**From:** Jonathan Best <[Jonathan.Best@arun.gov.uk](mailto:Jonathan.Best@arun.gov.uk)>  
**Sent:** 26 June 2026 14:58  
**To:** Planning.Responses <[Planning.Responses@arun.gov.uk](mailto:Planning.Responses@arun.gov.uk)>  
**Cc:** Simon Davis <[Simon.Davis@arun.gov.uk](mailto:Simon.Davis@arun.gov.uk)>  
**Subject:** WA/46/26/PL

Land At Freeman Close Walberton BN18 0AE.

I have reviewed this application with regards to ecology and Biodiversity Net Gain.

Recommendation: No objection subject to conditions.

Figure 3. UKHAB map showing proposed habitats within the site. The site boundary is indicated with a red line. Produced using QGIS software, version 3.40.5 – Bratislava.

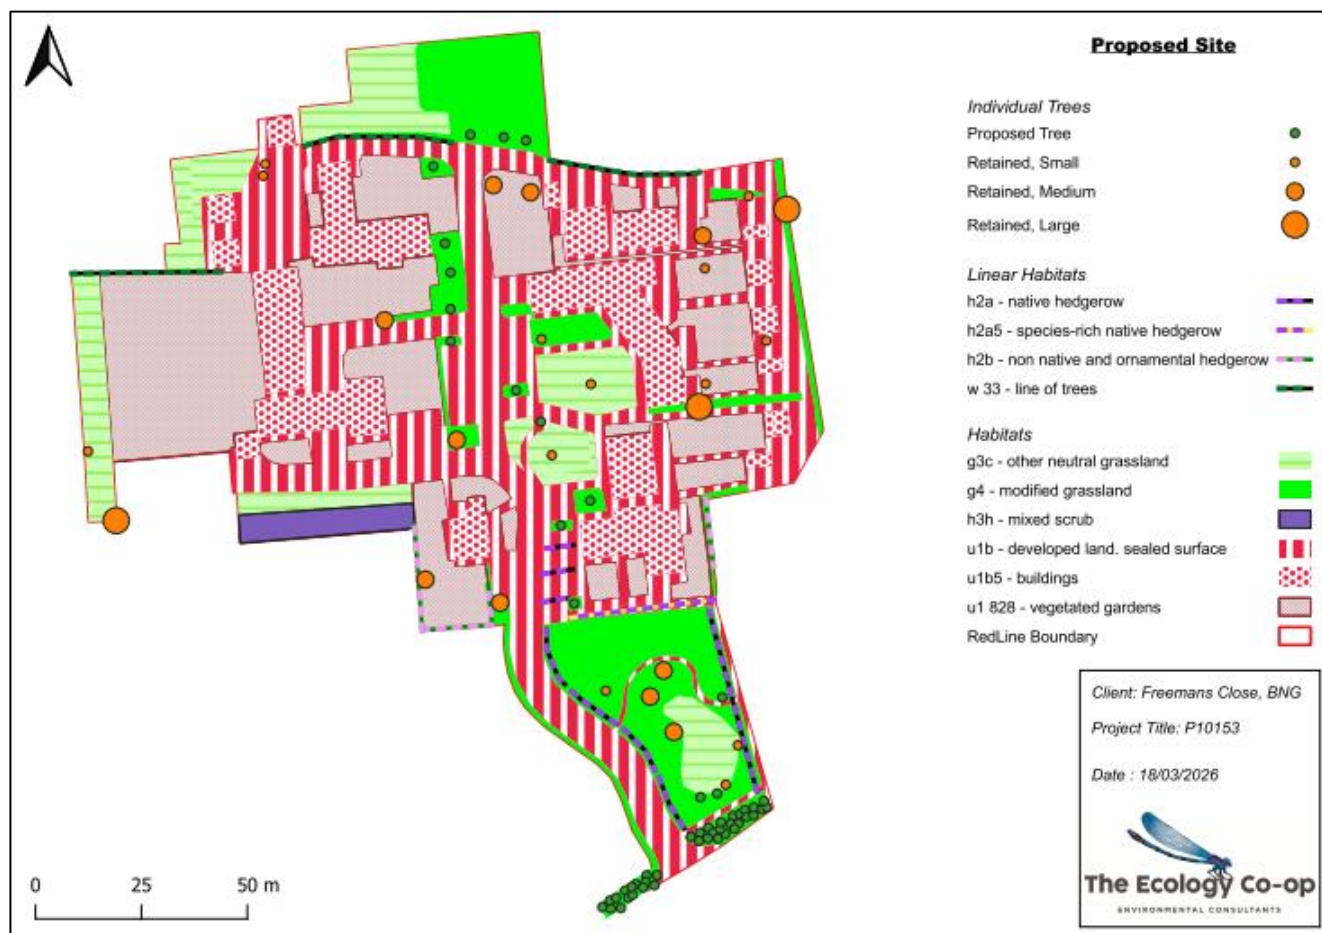
**TAB - A3.** The BNG metric proposes habitat enhancement of Other Neutral Grassland. The parcels G7, G9, G13, G22 and TF3 show enhancement to moderate condition in the comment's column but good condition in the condition change and post intervention columns. Clarification on this is required. If the target condition for ONG is moderate the onsite BNG may not achieve the required 10% uplift.
